**Planning Application 19/01047/OUT - Hallam Land Management Ltd, Land North East of Oxford Road, West of Oxford Canal and East of Bankside Banbury.**

Adderbury Parish Council objects to the above application on the following grounds:

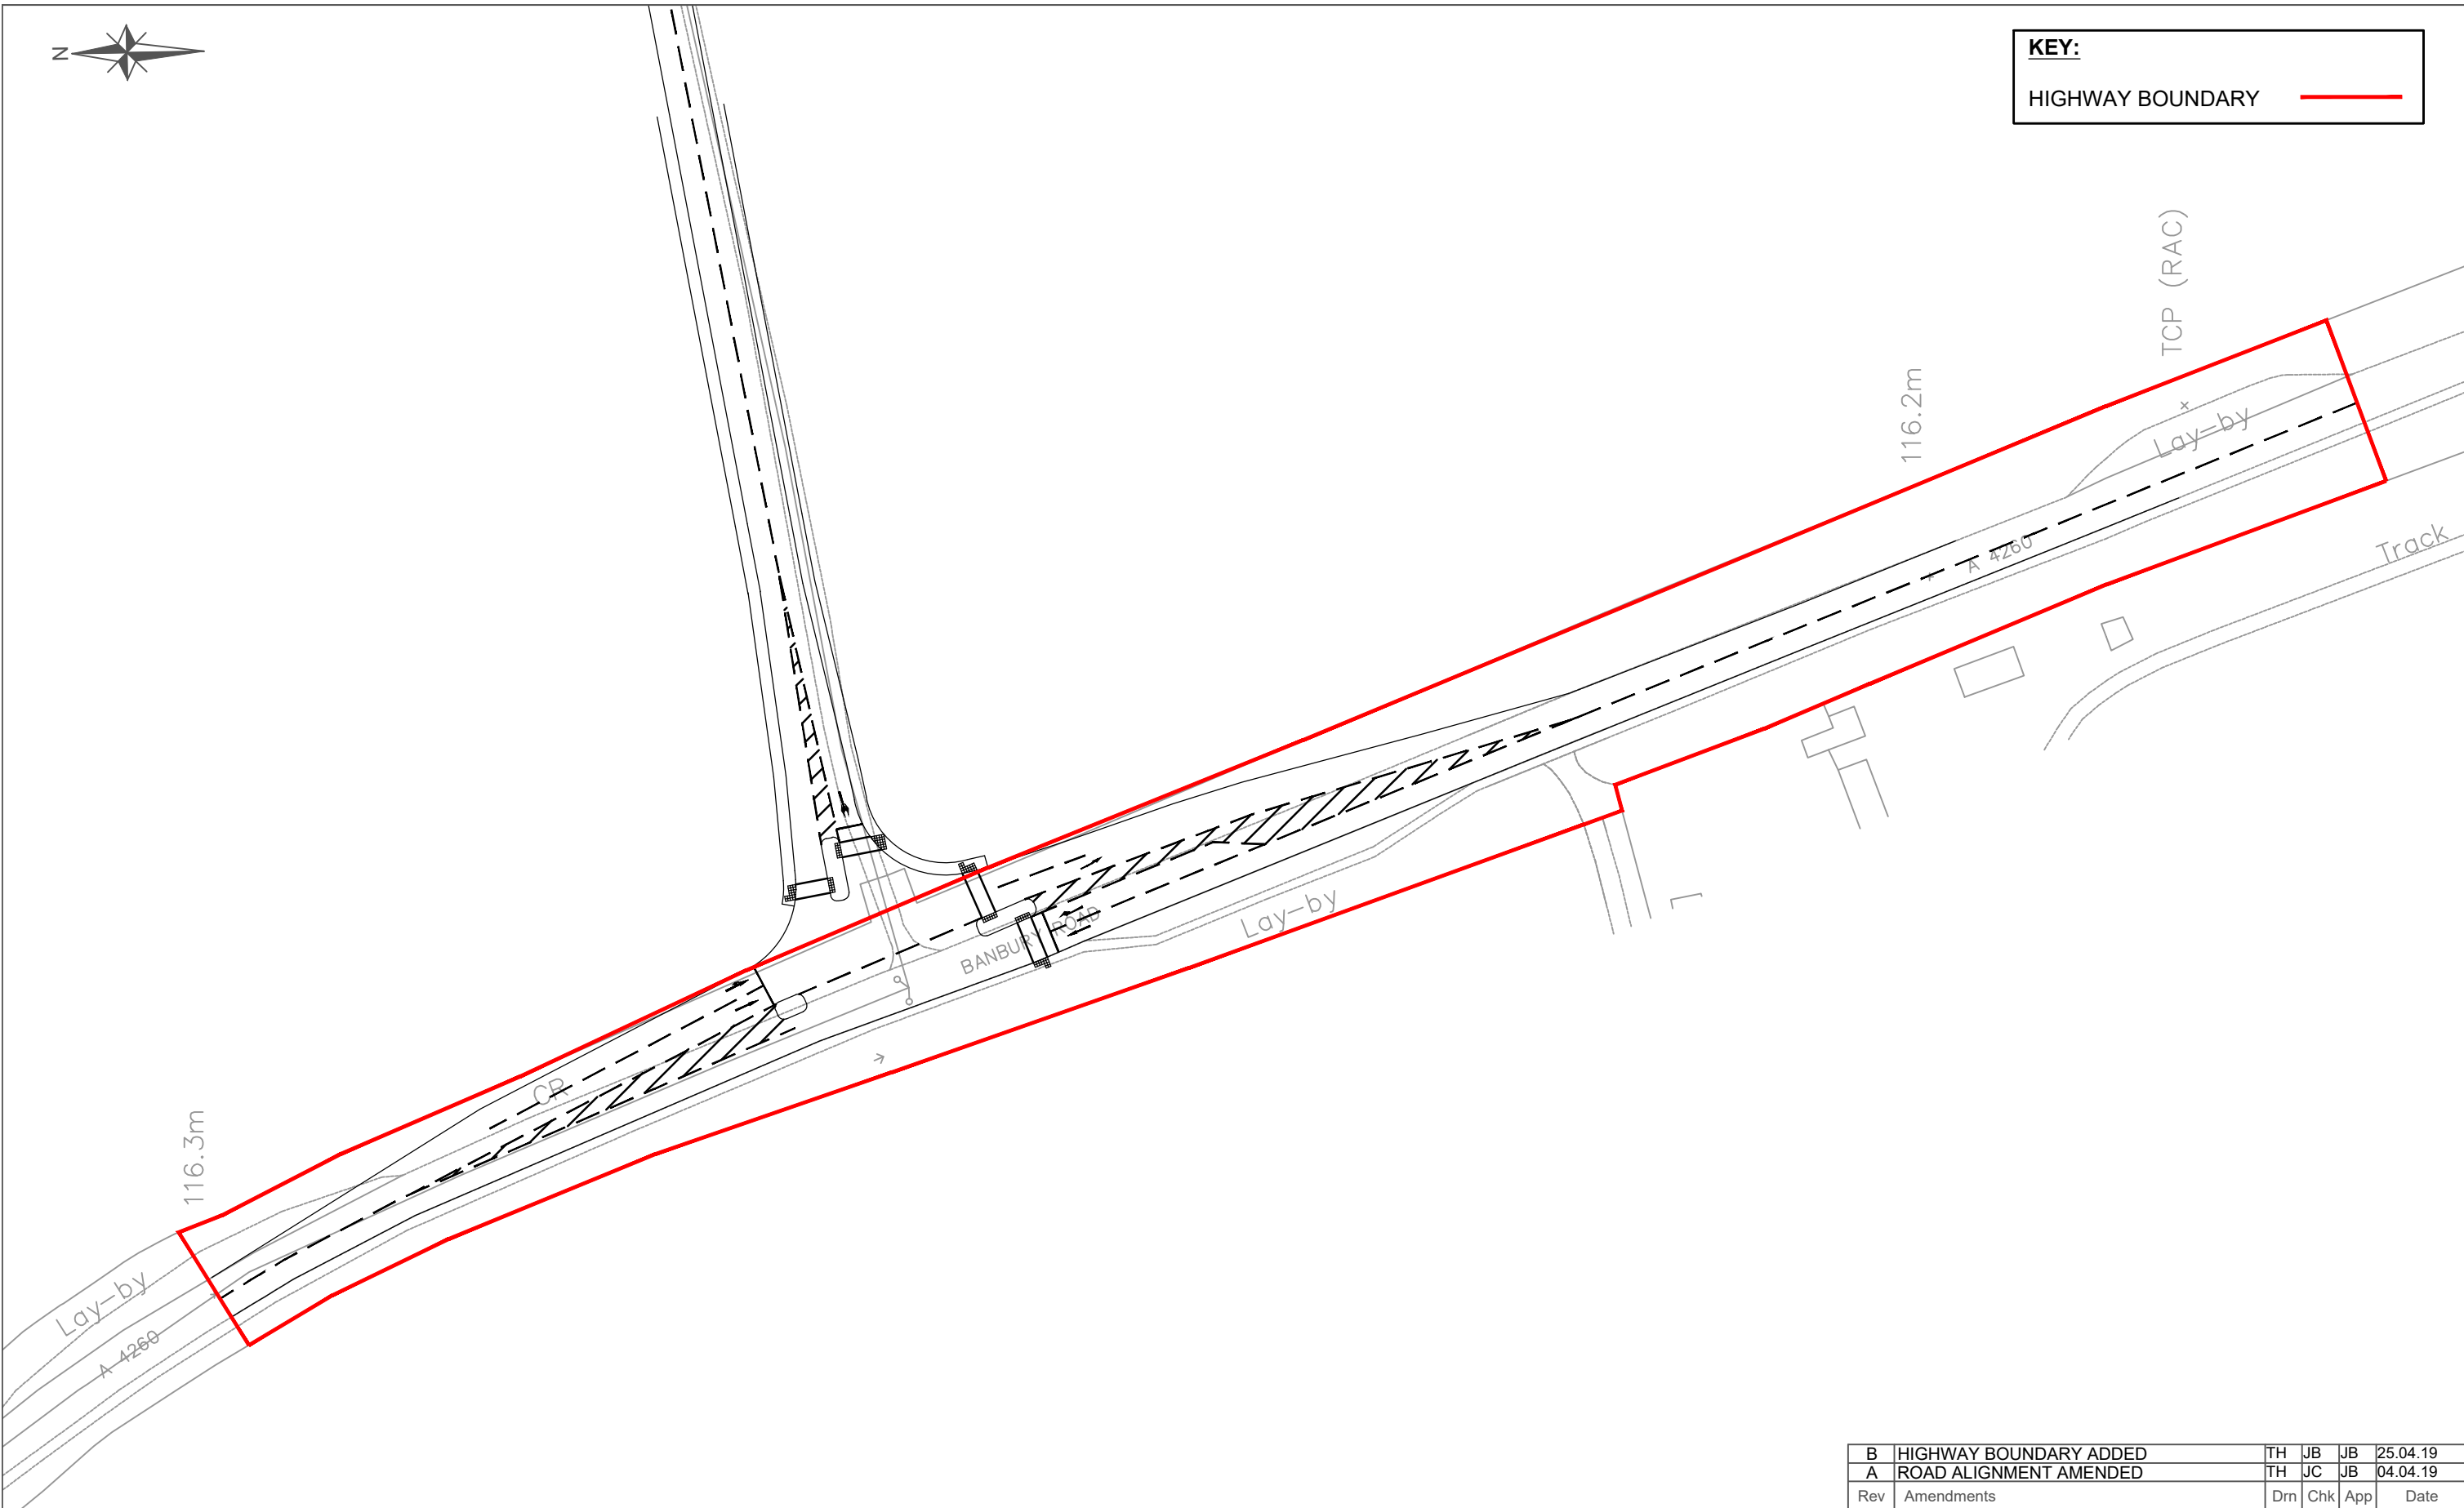
2. The provision of another junction on the A4260 will only add to the delays motorists face in travelling to and from Banbury. The PC does not agree with the transport consultants working for the developers who see no problems with the application. The PC wishes to draw attention to the County Council Highway's own efforts to manage the traffic lights at the A4260/B4100 (Aynho Rd) junction which has not yet successfully prevented traffic congestion. At peak times cars can be backed up passed Weeping Cross in Bodicote and Duchess Bridge in Adderbury, and past Katharine House entrance on Aynho Road.

3. The existing junction into Longford Park has not been well designed. It has dangerous line markings on both sides of the road, allowing forward moving traffic to take the inner or outer lane and leading to a race as the road narrows to a single lane forwards. The lane leading south away from Banbury, has a bus stop in the inner lane and regularly provokes dangerous manoeuvring of motor vehicles. This bus stop needs moving somewhere else.

The PC objects to any similarly designed junction being added to this very busy road.
